Ribble Valley Borough Council  
Council Offices  
Church Walk,  
Clitheroe  
Lancashire  
BB7 2RA

Phone: 0300 123 6780  
Email: [Kathryn.Walsh@lancashire.gov.uk](mailto:Kathryn.Walsh@lancashire.gov.uk)  
Your ref: 3/2024/0825  
Our ref: 3/2024/0825/HDC/KW  
Date: 09 December 2024

**Location:** 59 Downham Road Chatburn BB7 4AU  
**Proposal:** Proposed conversion and alteration of the two-storey existing garage to form additional living accommodation and a glazed link extension joining it to the main house.  
**Grid Ref:** 377301 444242

A2.2

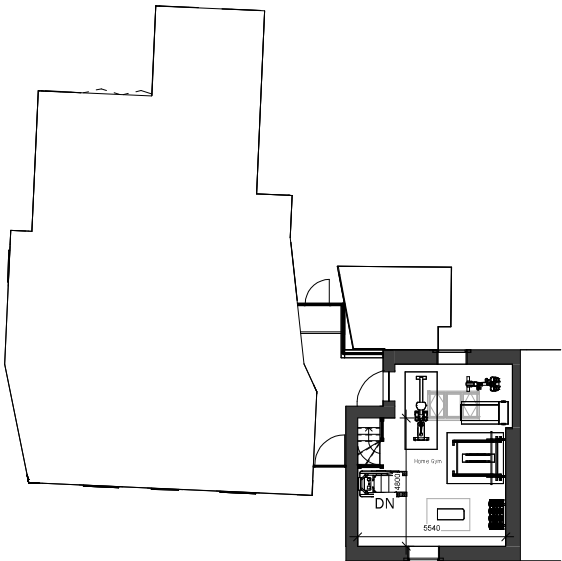
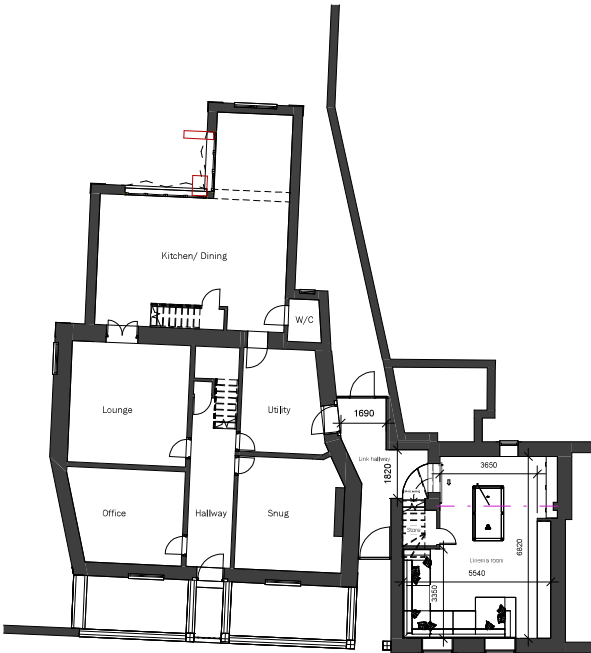
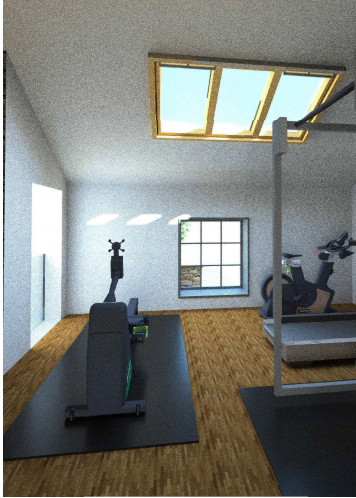
As the garage is to be removed, the existing vehicle crossing will no longer be required and therefore shall be removed and the footway shall be reinstated. The footway reinstatement will need to be undertaken as part of a Section 278 agreement of the 1980 Highways Act.

1. No part of the development hereby approved shall commence until all the highway works (reinstatement of footway) have been constructed and completed in accordance with a scheme that shall be submitted to and approved by the Local Planning Authority in consultation with the Highway Authority.
